From: Jonathan Best
Sent: 27 January 2025 09:56
To: Planning.Responses
Cc: Simon Davis
Subject: AL/143/24/RES

Land adjacent to Woodgate Nurseries Lidsey Road Aldingbourne PO20 3SU.

I have reviewed this application with regards to ecology.

TITLE PRELIMINARY LIGHTING DESIGN

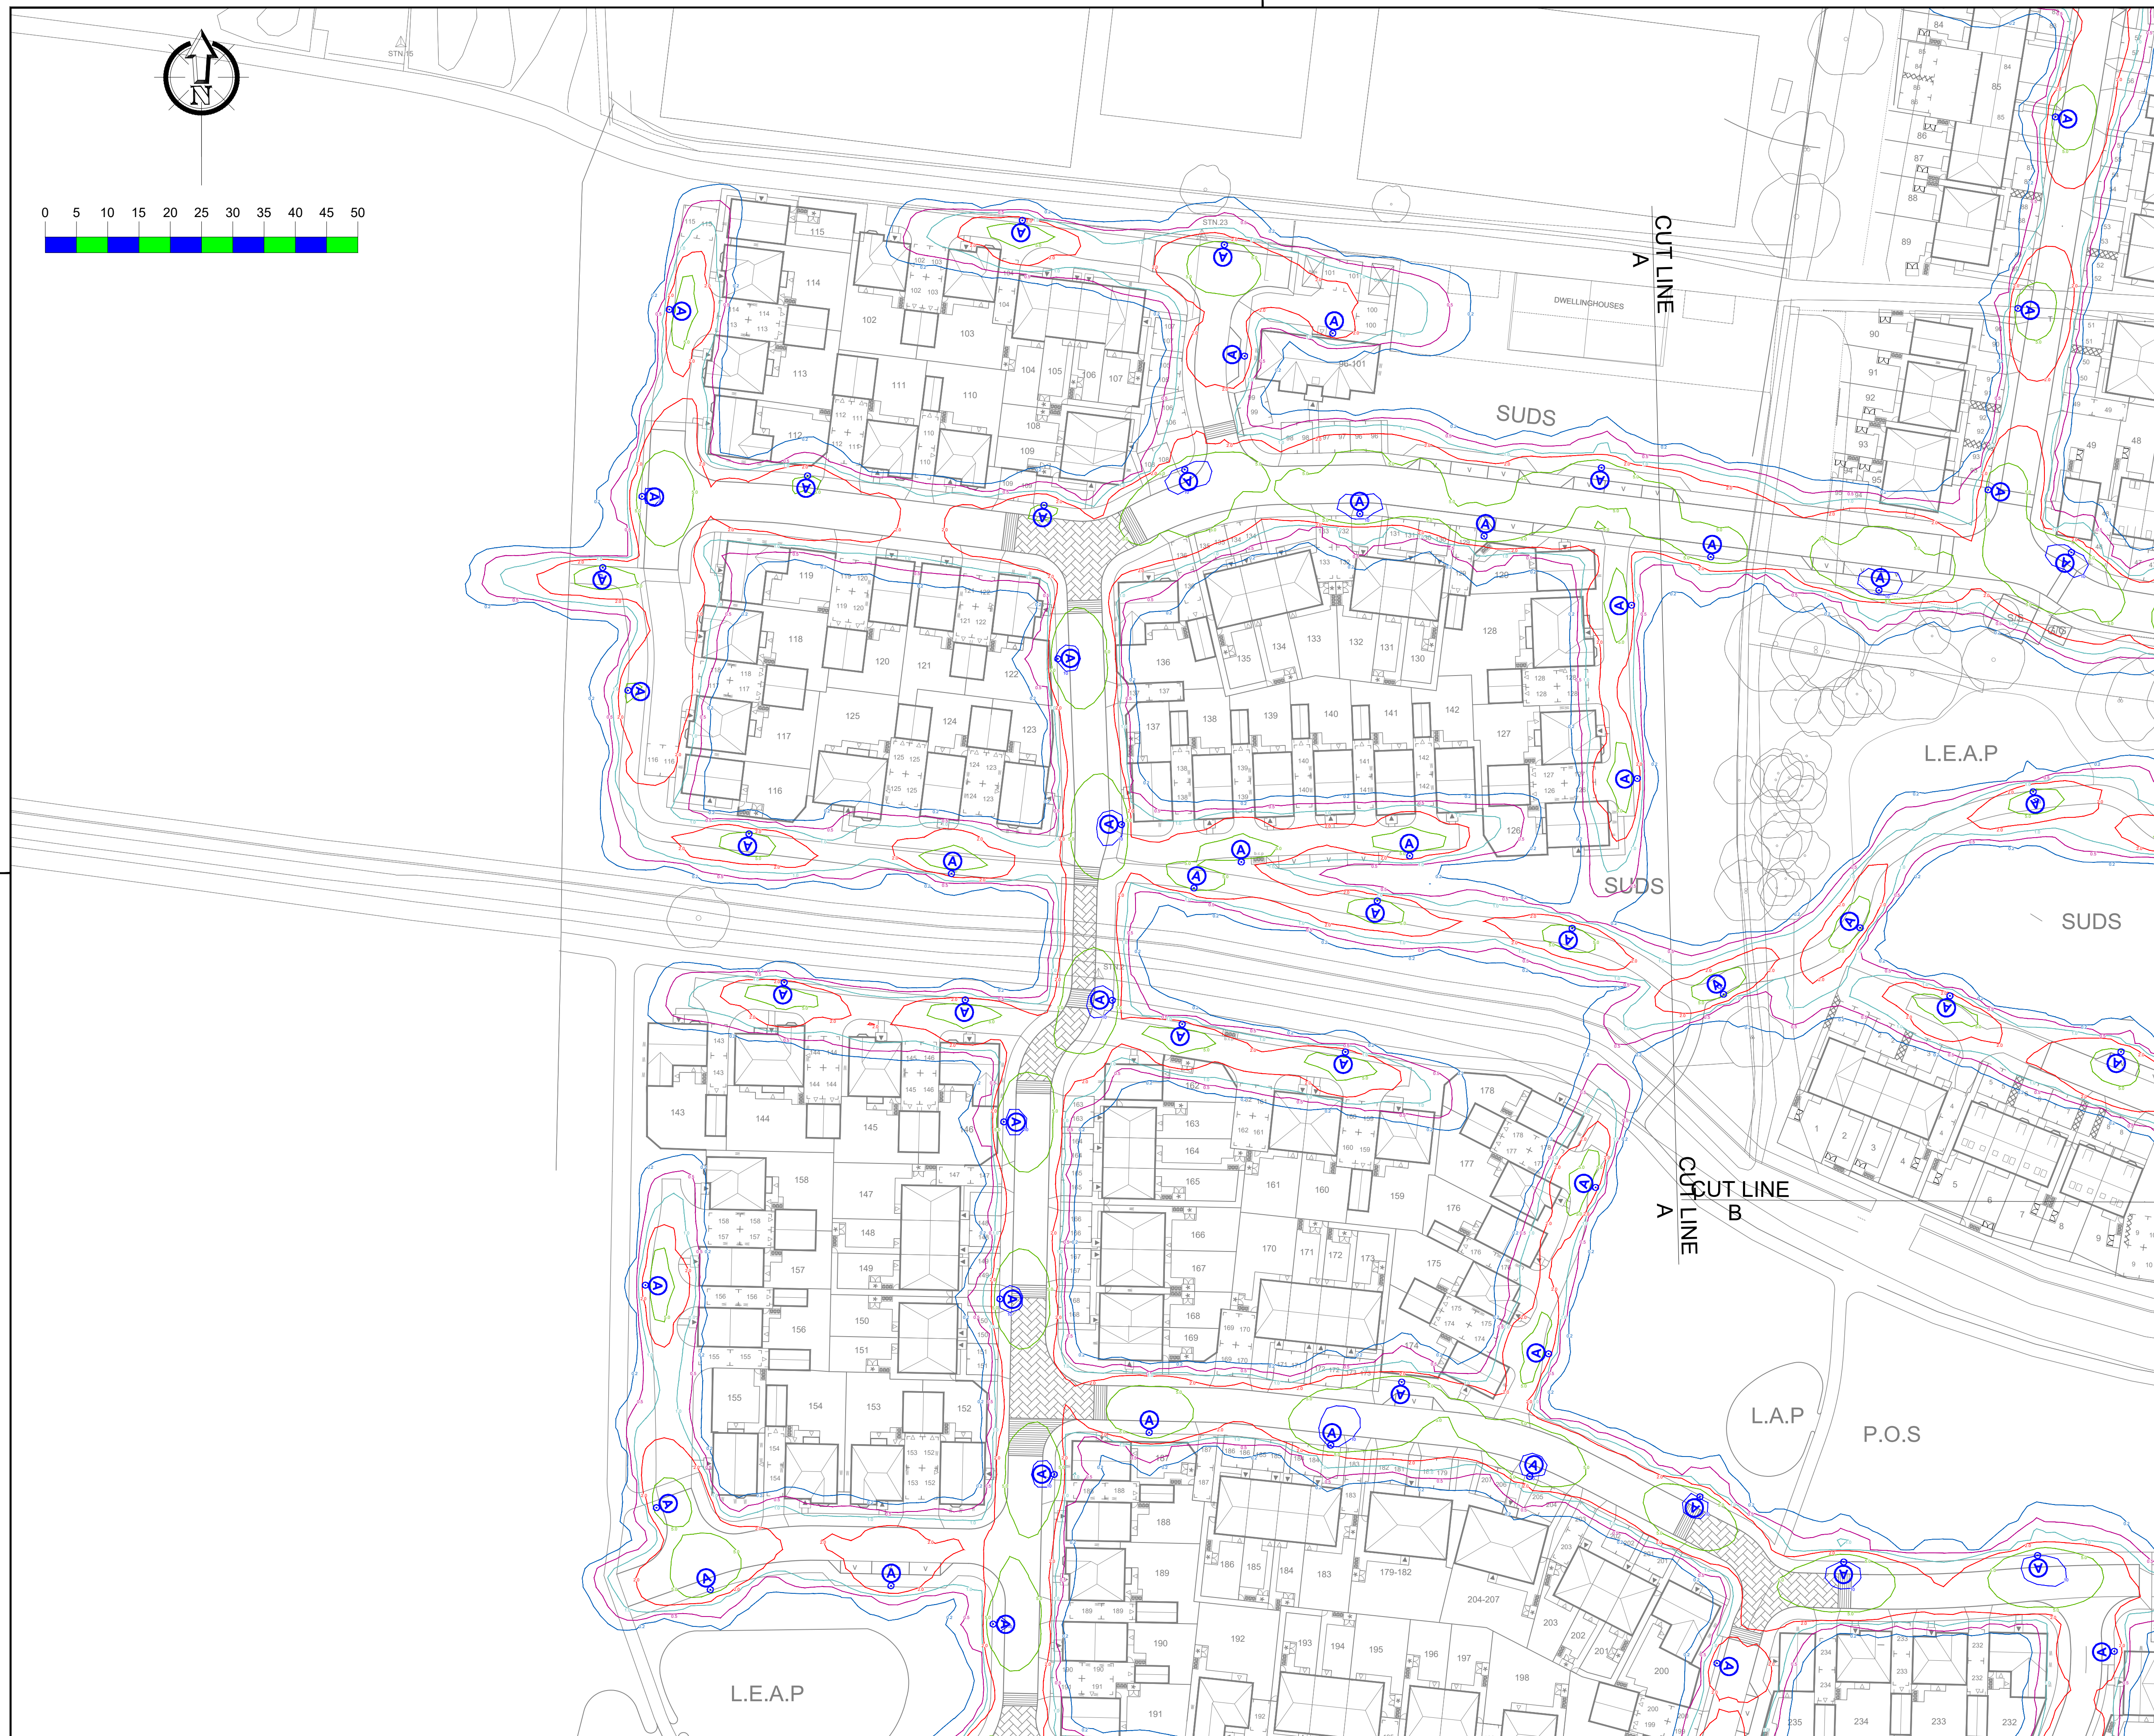
The Lighting Plan is fine and meets best practice for bats.

Title: Play and Open Space Proposals Sheet 3

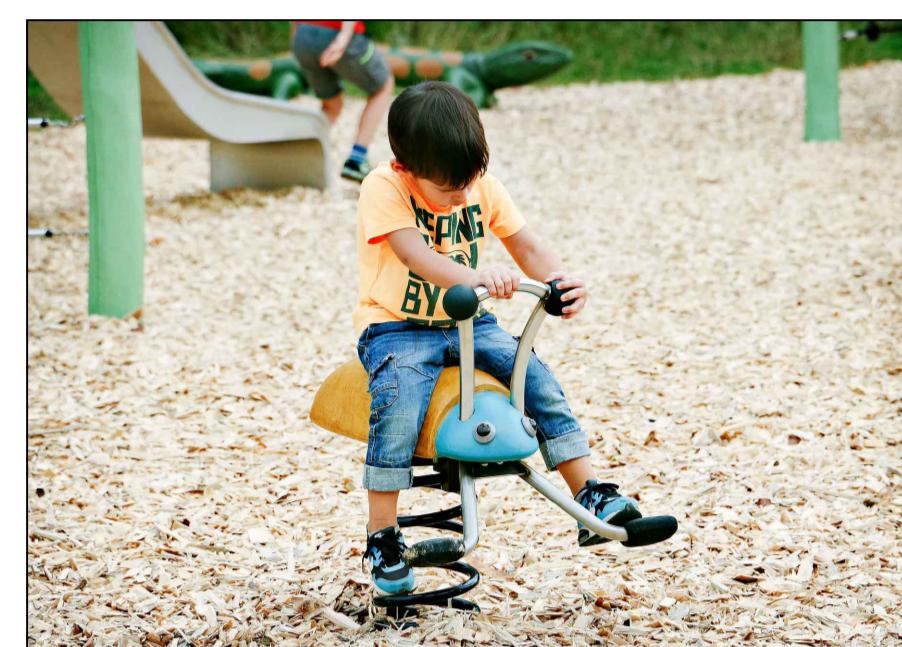
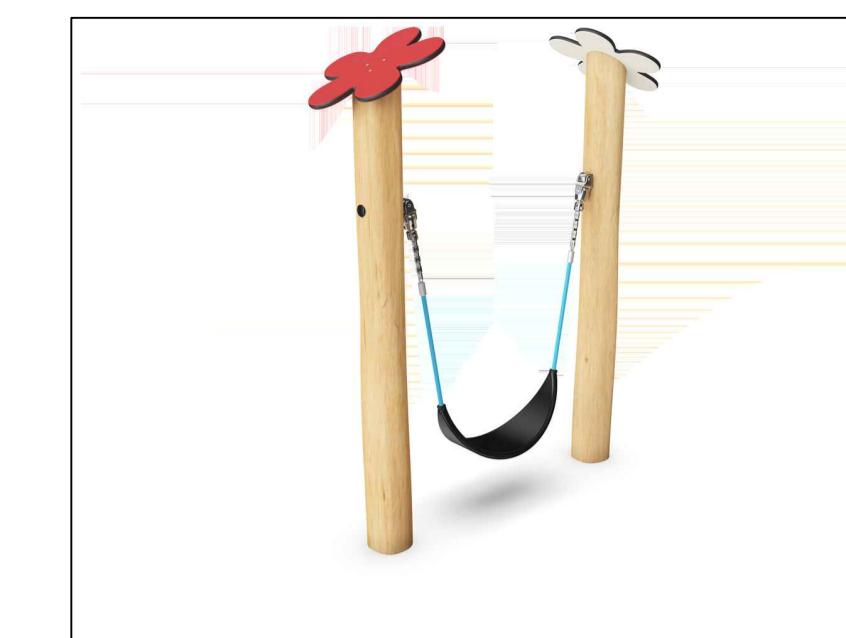
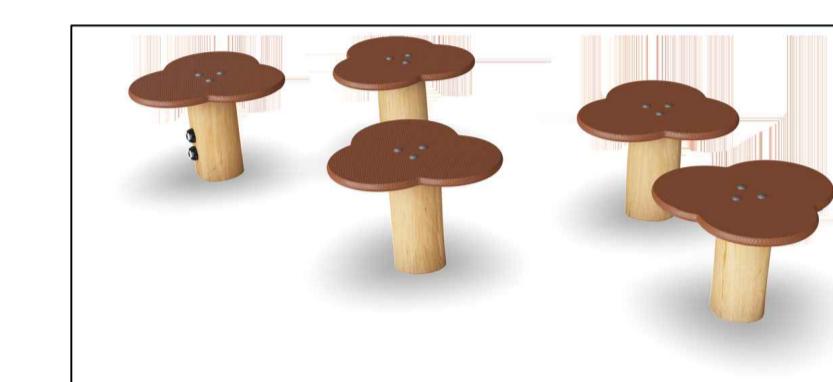
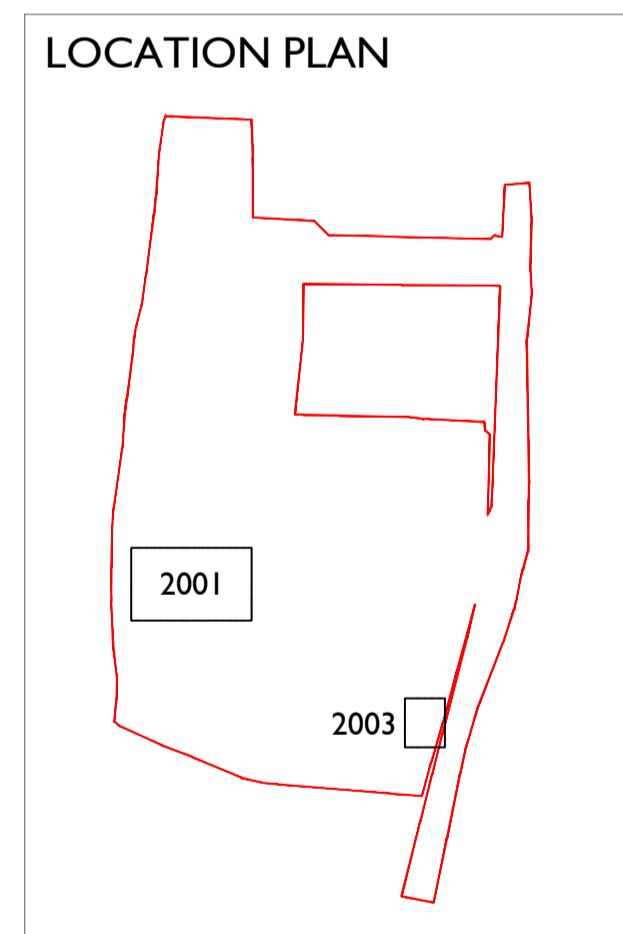
The native hedgerow species mix proposed in the Play and Open Space Proposals Sheet 3 do not meet the requirements of the EIA. There is no Hawthorn, and the mix only contain 4 species in total instead of the six required.

The ornamental shrub planting contains only 6 species for 156 plants. Again, I feel the diversity should be increased to benefit birds and pollinators. **Applicant response:** The landscaping details have been updated to reflect the changes requested to planting details
